Our Ref: EG/7/17/HH
Your Ref:

Town & Country Planning Act 1990 (as amended)
Town & country Planning (Development Management Procedure) (England) Order 2015
Application for Planning Permission for Works or Extension to a Dwelling

Development Construction of a single-storey telescopic pool enclosure above existing outdoor pool.
Location 1 Wandleys Close Fontwell Eastergate

VAWER COUPE VERTI2

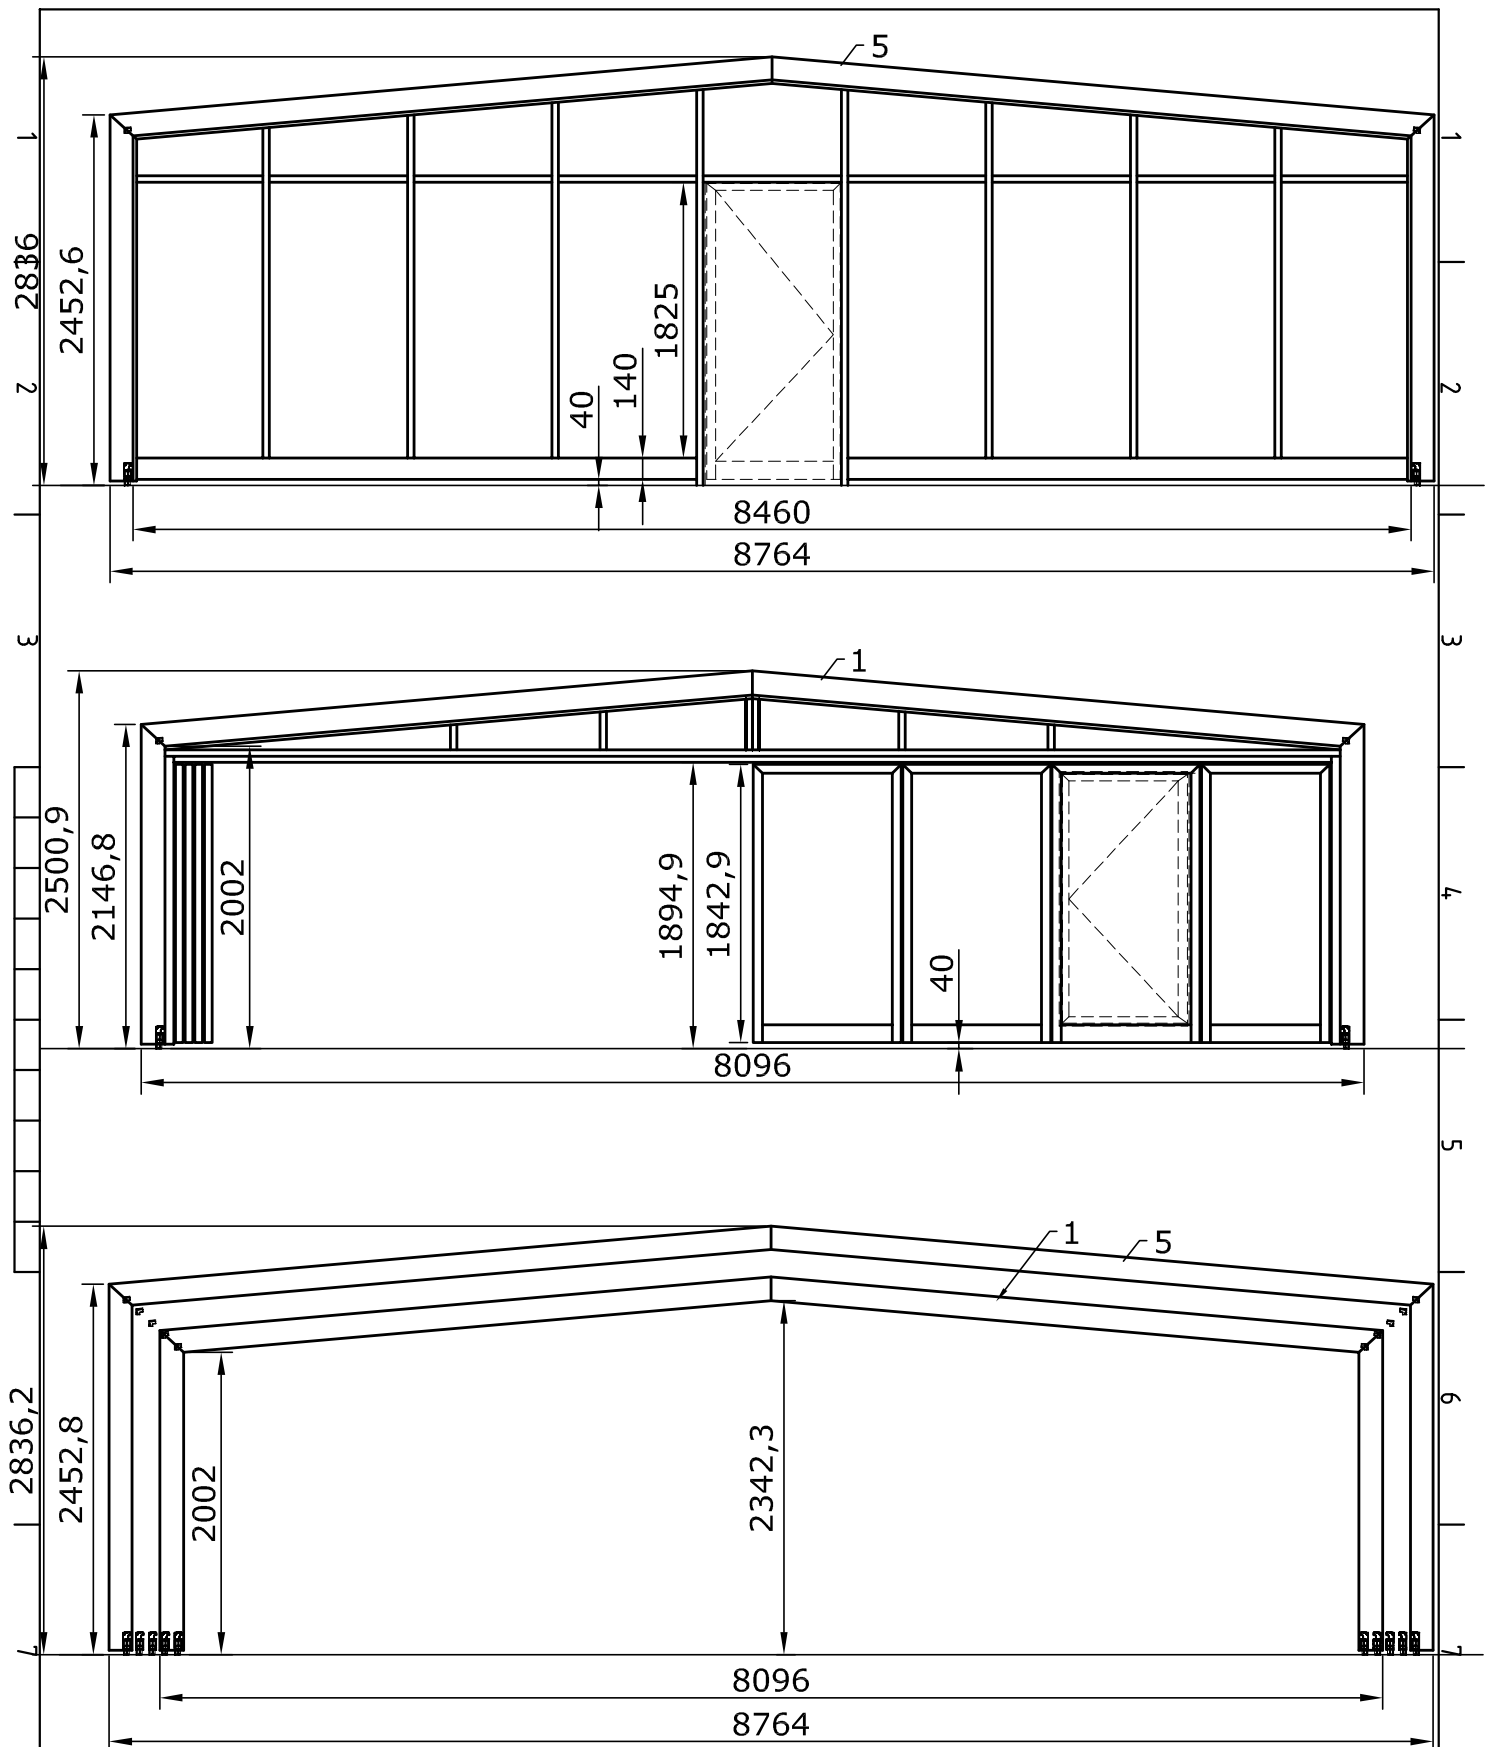
Scale

Please label the scale to which the floor plans and elevations have been drawn;

Plans Inconsistent

The height is different between the elevations. The total height would be visible from the front elevation

DRAW : LC DATE : 07/02/17 Prof: C15 VAWER COUPE LAT

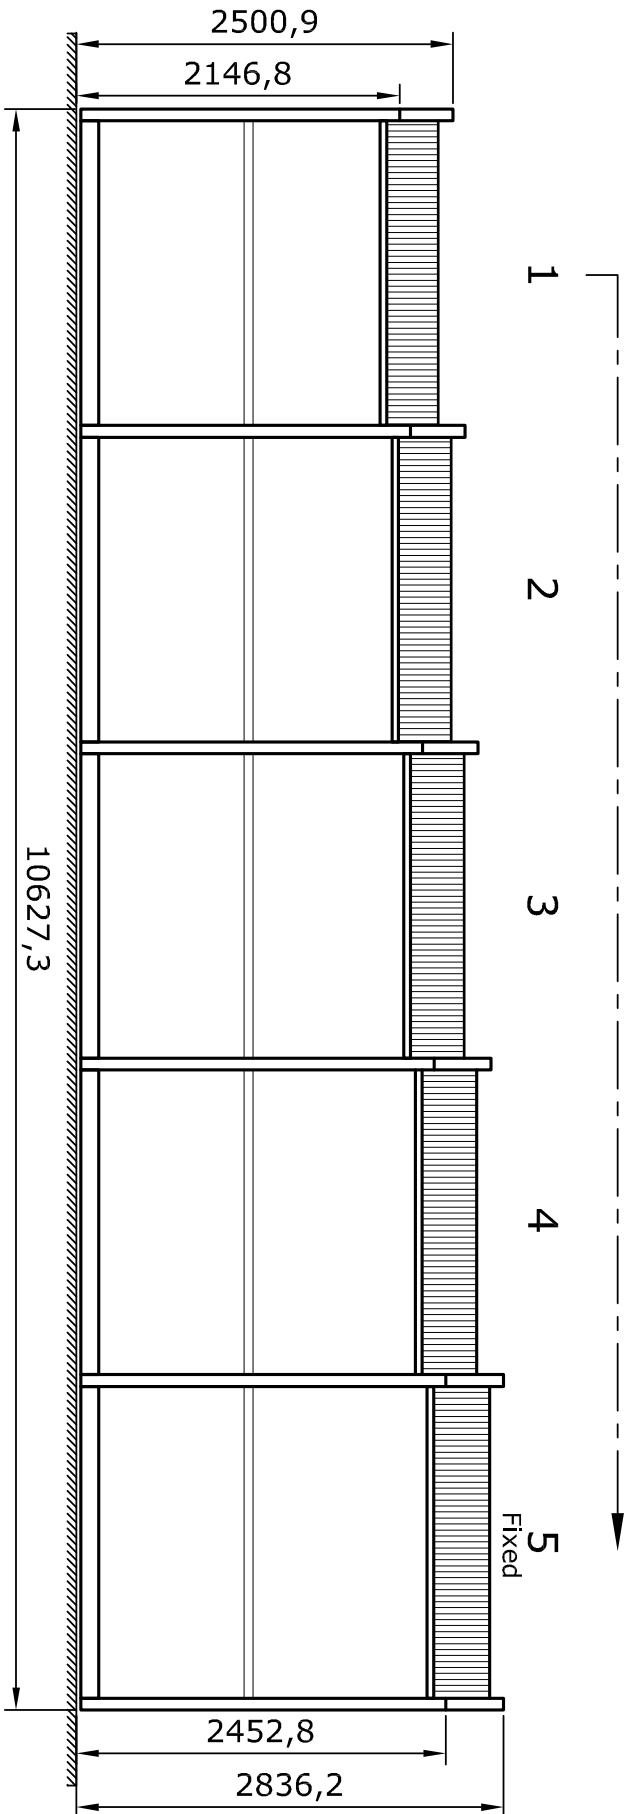
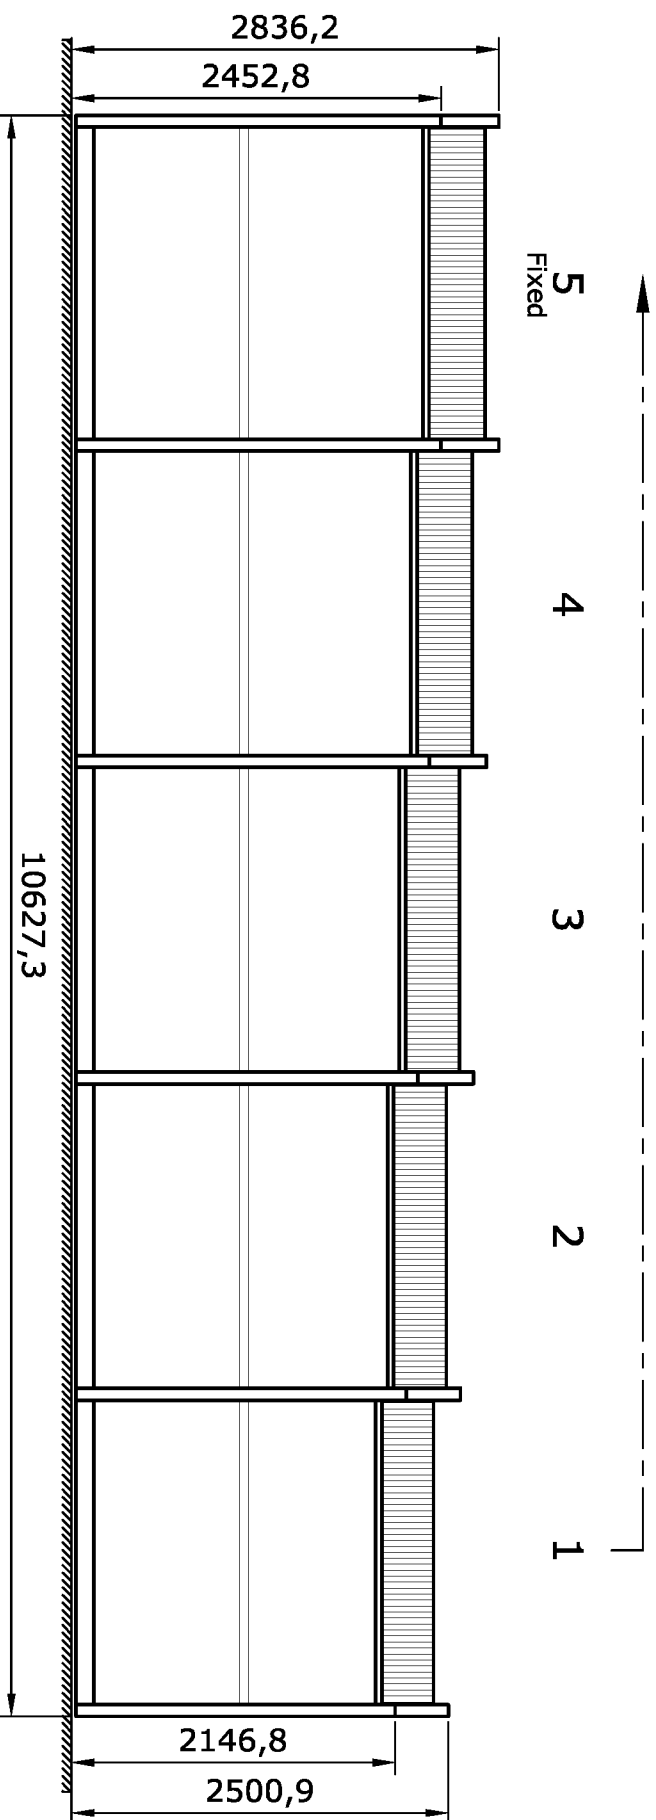
Elevations

Please submit 1 electronic or 3 paper copies of clearly labelled proposed side elevations at a scale of 1:50 or 1:100. Further details can be found in the National Validation Requirements.
